**CITY OF ALBUQUERQUE  
PLANNING DEPARTMENT  
October 9, 2013  
DRB Comments**

**PROJECT # 1009414**

**RE: Lot 2A, Paradise Hills Subdivision**

TITLE: PASEO DEL NORTE/UNSER  
 TEMPORARY PARK AND RIDE FACILITY  
 SKETCH PLAT

TITLE: PASEO DEL NORTE/UNSER  
 TEMPORARY PARK AND RIDE FACILITY  
 SKETCH PLAT

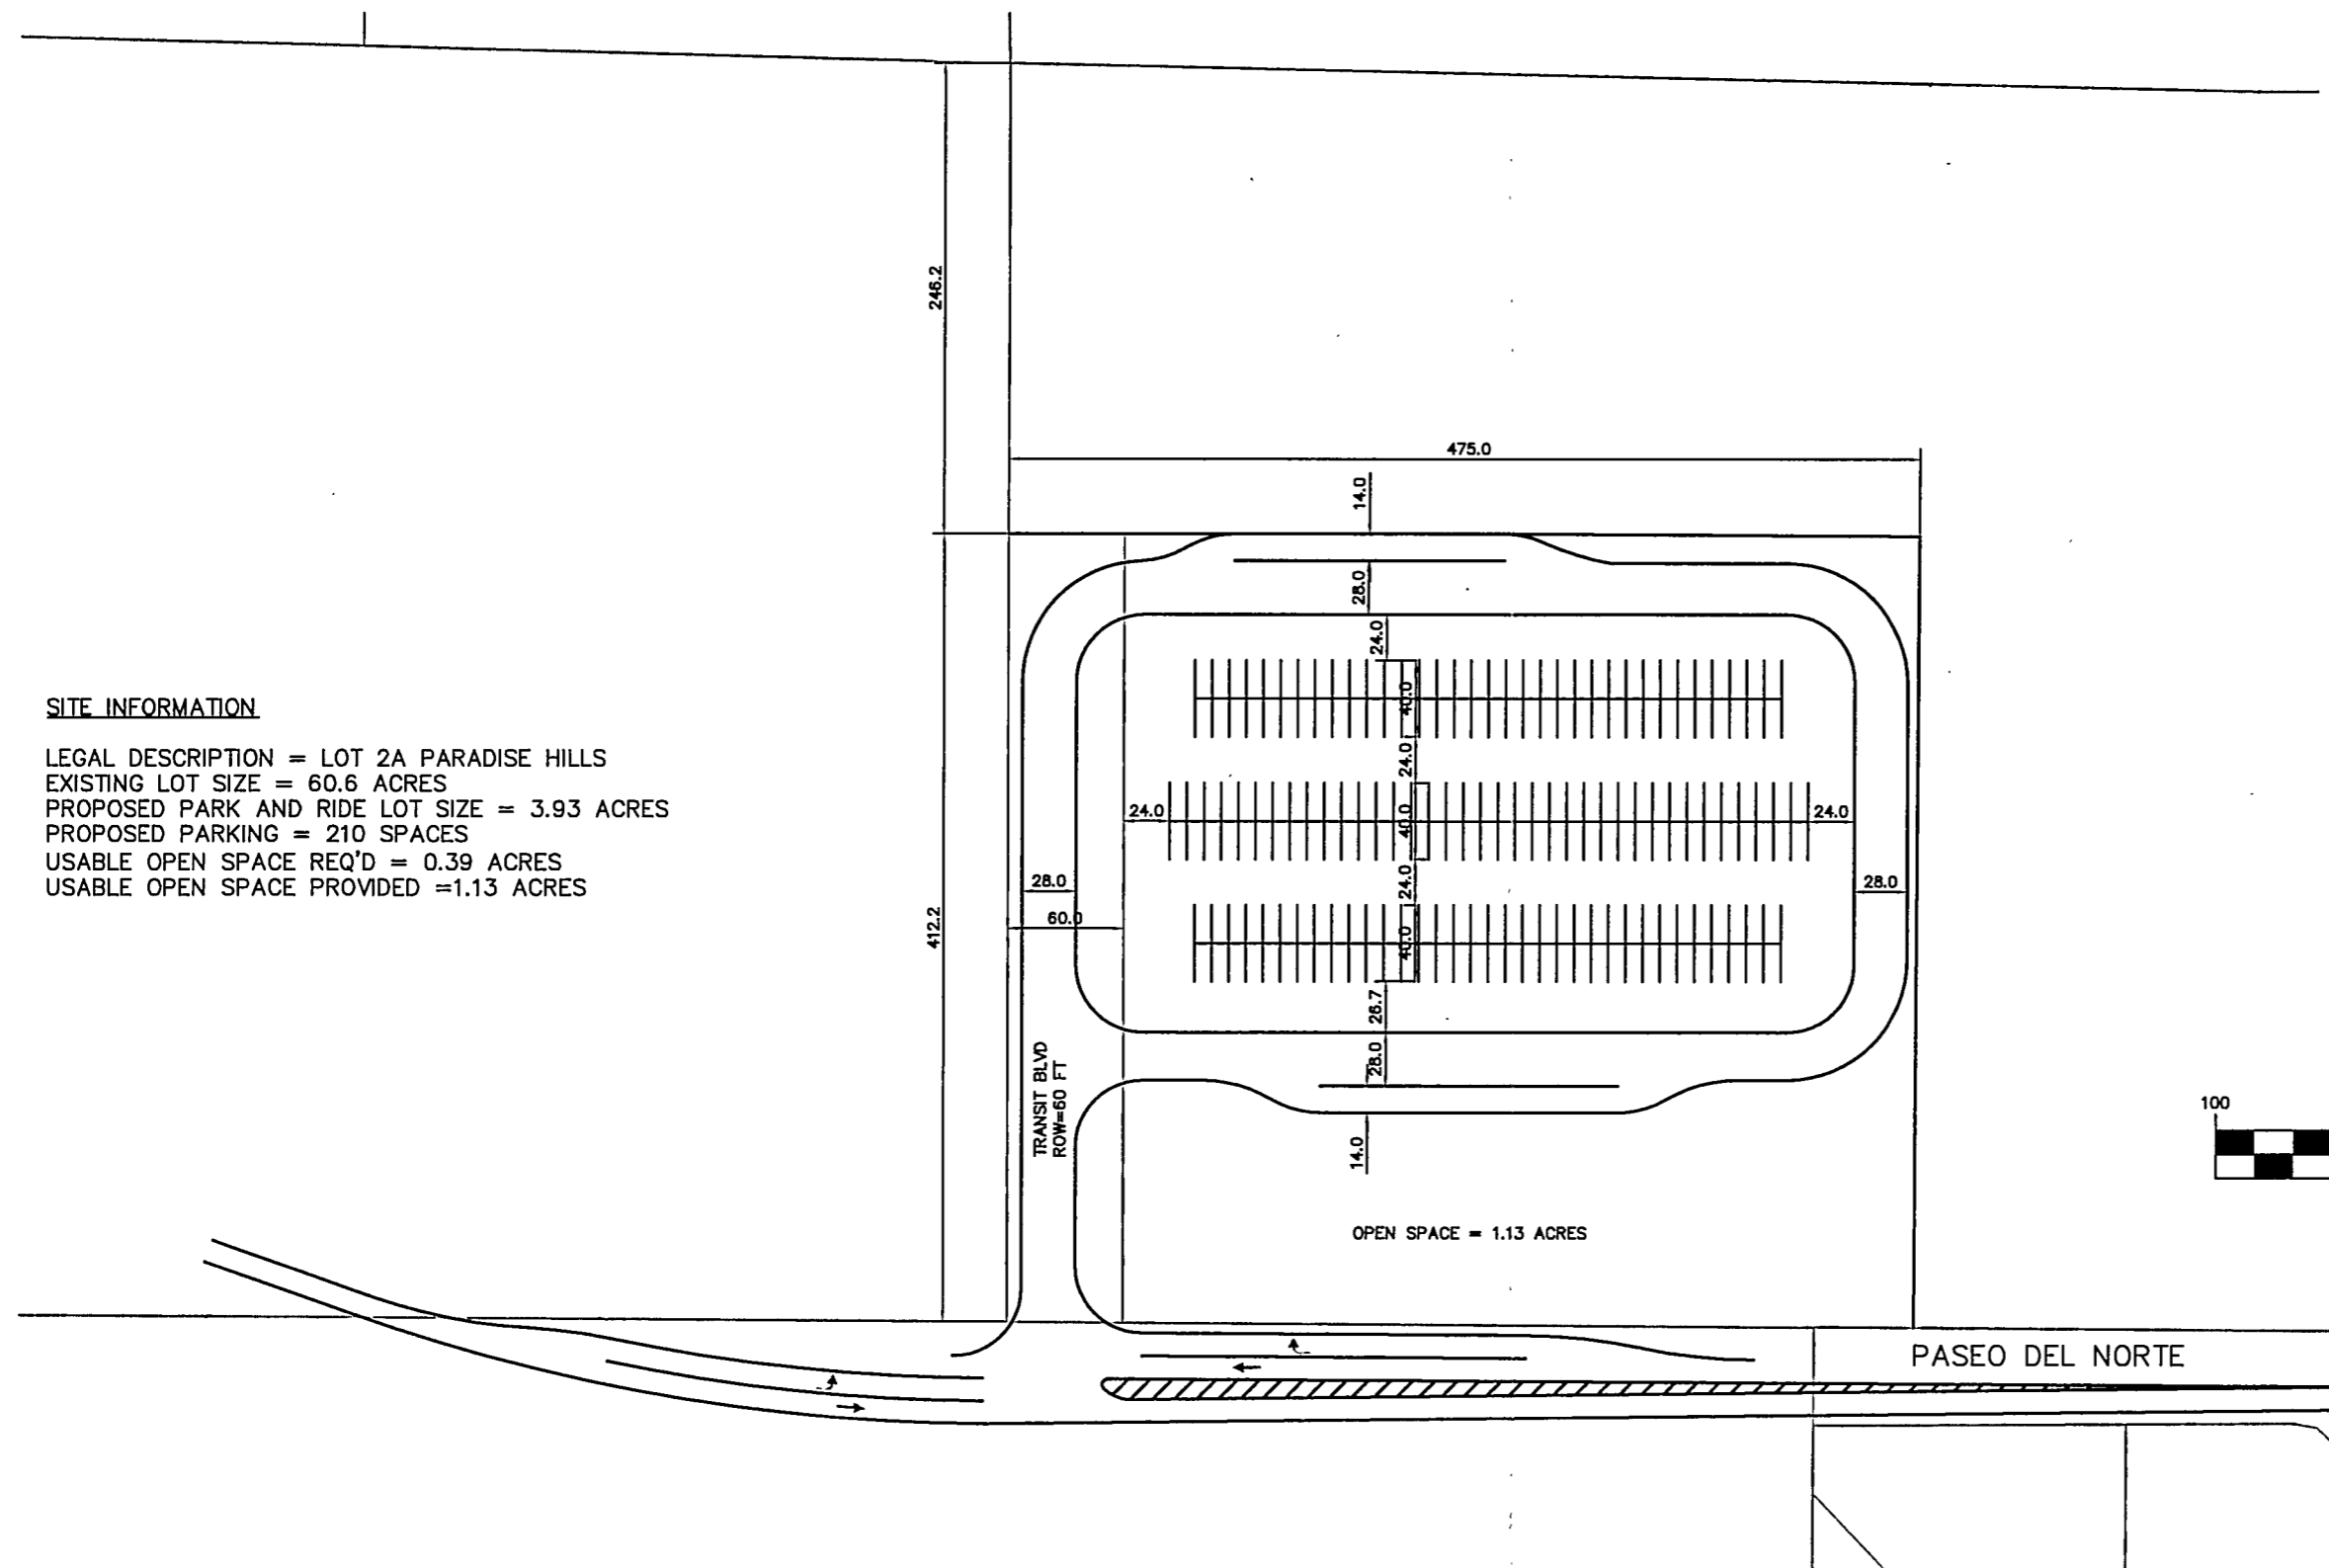
More information is needed on 'temporary' extent of proposed project. See attached Site Development Plan for Subdivision Checklist for minimum submittal requirements if infrastructure is required; refer to sector plan for development regulations.
